**Re: Recovery Support Center
521 Cardenas Dr. SE
Traffic Circulation Layout
Engineer's Stamp 3-13-2023 (L18D086)**

BERNALILLO COUNTY RECOVERY SUPPORT CENTER
Traffic Circulation Layout (TCL) Letter of Response - 2

A1 TRAFFIC CIRCULATION LAYOUT

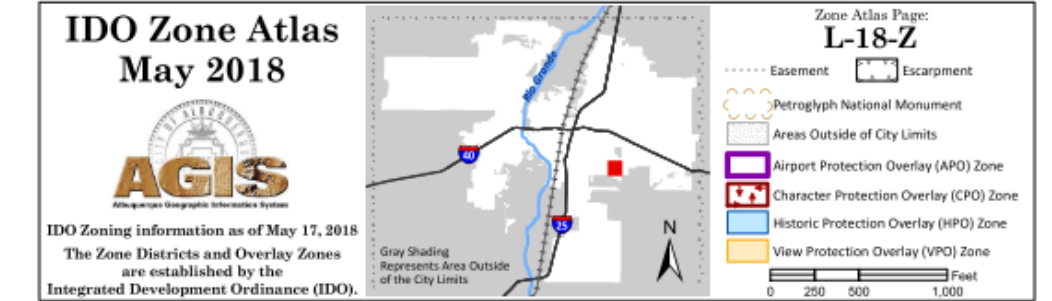
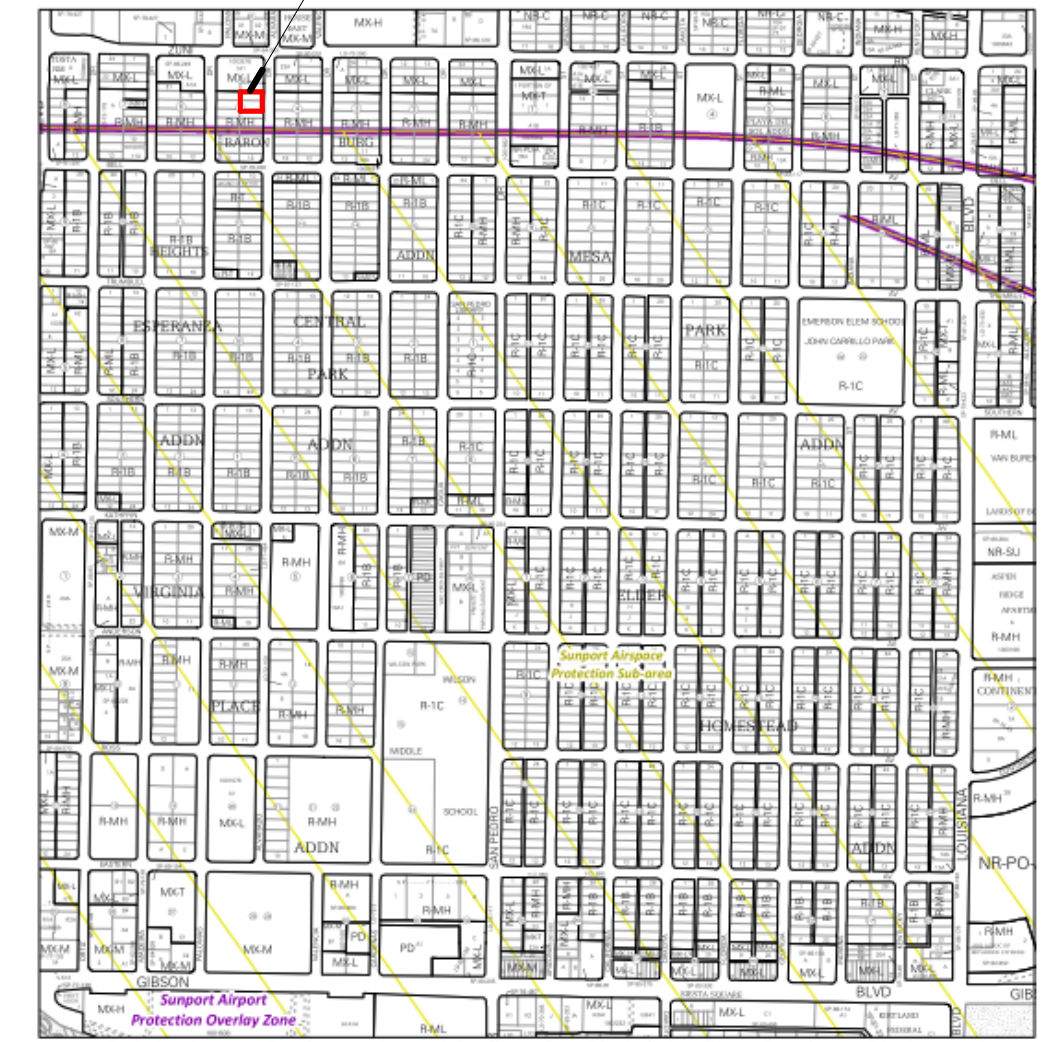
2. Per the DPM, on street parking spaces minimum length is 20 ft and minimum stall width is 7 ft.
 - a. *See updated TCL drawing with street parking spaces dimensioned. All meet minimum requirements.*

3. The north side site access must be updated to the current ADA standard. And please relocate the "DO NOT ENTER" sign. A Do Not Enter sign indicates that the drivers are often going to encounter opposing traffic. It should be shown to the driver when entering from the exit.

4. Please reference COA std dwg 2425B for the proposed site ingress drivepad.
 - a. *See General Note #2. New drivepad to meet requirements of 'Drivepad with sidewalk at back of curb'.*

5. Provide a copy of Fire Marshall Approval
 - a. *See attached, signed MOU between the City and County*
6. Unused curb cuts must be replaced with sidewalk and curb & gutter. A build note must be provided referring to the appropriate City Standard drawing.

- a. *"Do Not Enter" sign has been relocated, see updated TCL drawing.*
 - b. *Per phone conversation on 6/8/2023, there is no need to upgrade north site access. Drivepad referenced is located on neighbor's property and not part of the project scope.*

- a. *See General Note #1*
